Application for a non-material amendment following a grant of planning permission.

Number	10
Suffix	
Property name	
Address line 1	Love Lane
Address line 2	
Address line 3	
Town/city	Bridgnorth
Postcode	WV16 4HD
Description of site location must be completed if postcode is not known:	
Easting (x)	371779
Northing (y)	293702
Description

<input type="text" value="Erection of 1No dwelling, double garage and improvements to original access and parking to existing property (re-submission)   Proposed Dwelling West Of 10 Love Lane Bridgnorth Shropshire"/>	
Reference number:	<input type="text" value="17/05903/FUL"/>
Date of decision	<input type="text" value="01/03/2018"/>

Replace approved french doors with bi-fold doors & introduction of proposed french doors

Proposed Elevations

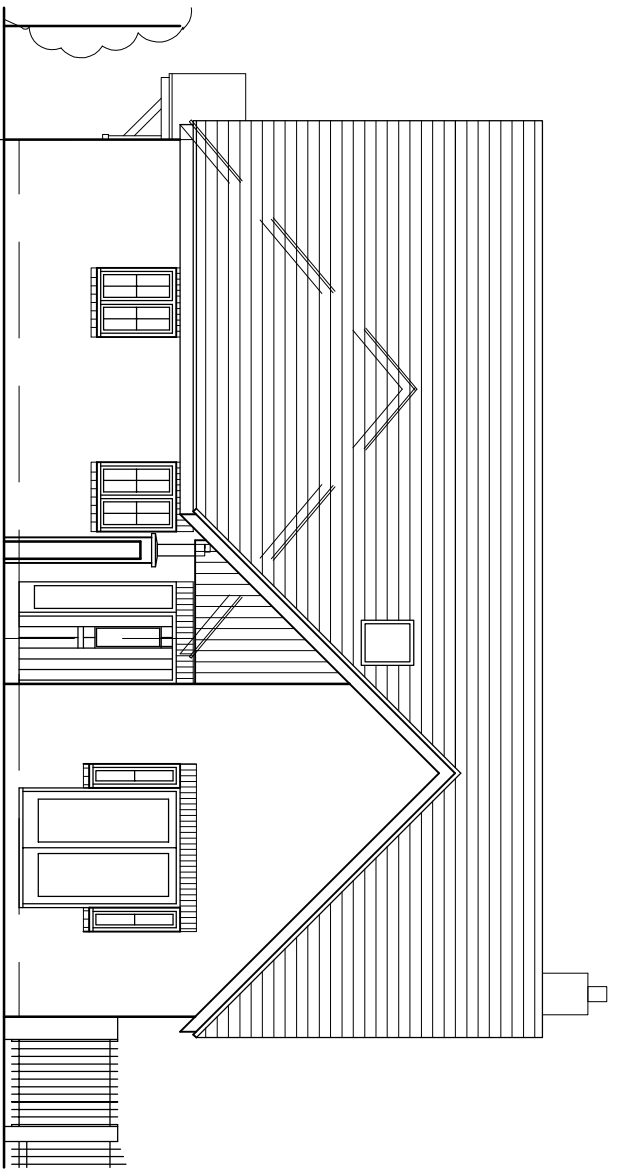
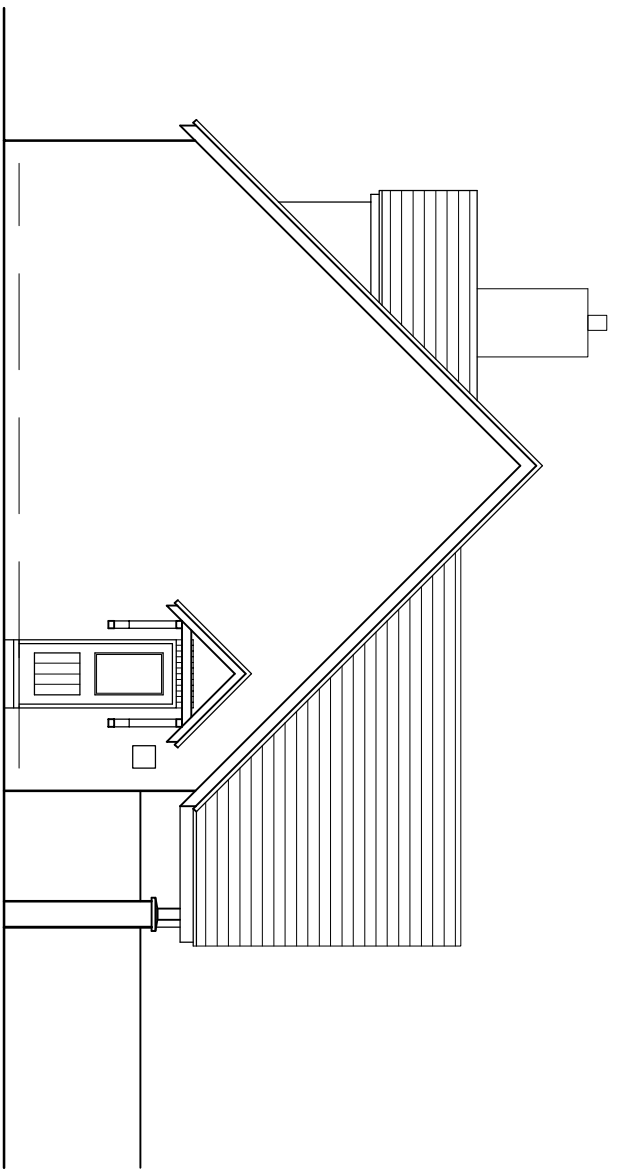
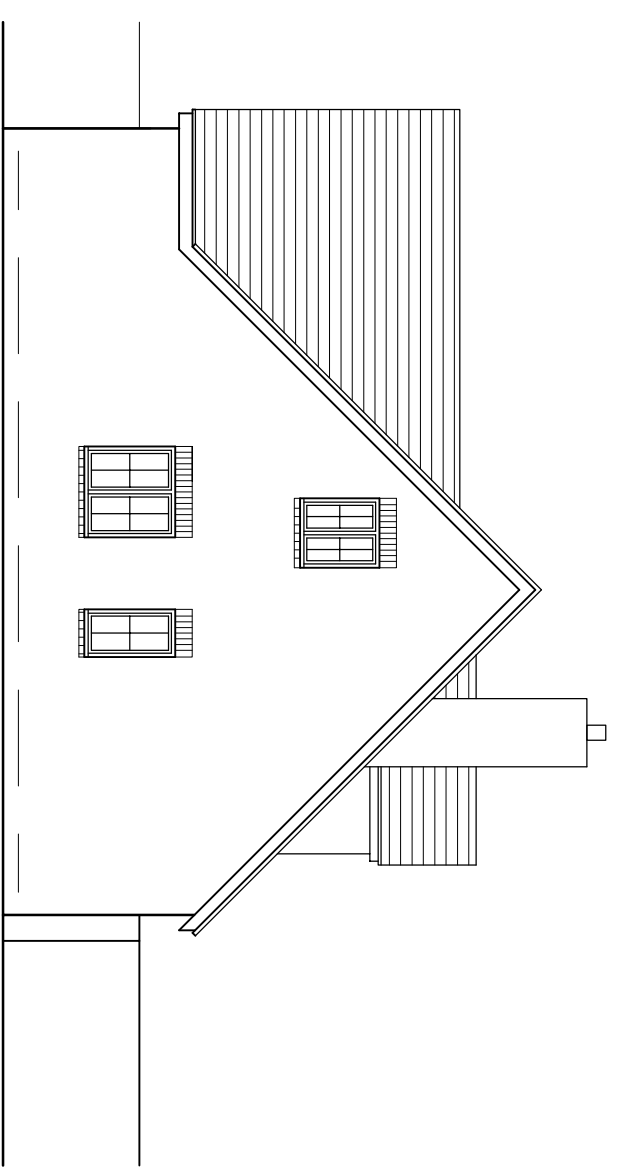
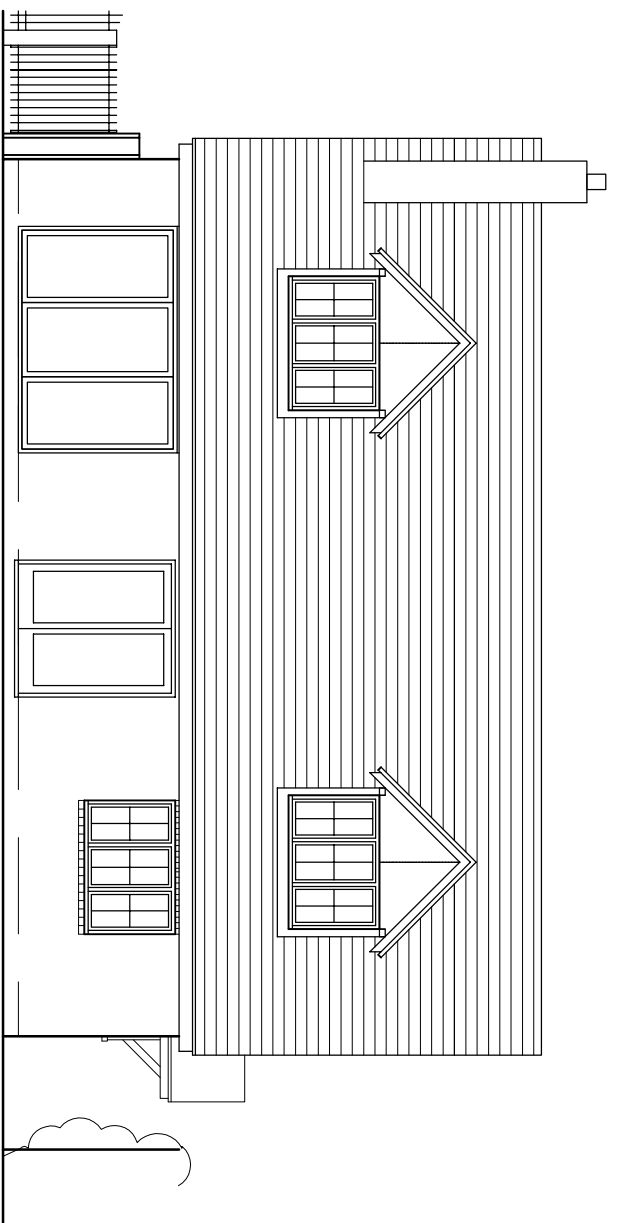
12097/SK003  
12097/SK005

20072/100  
20072/300

Applicant preference to allow more light into living area
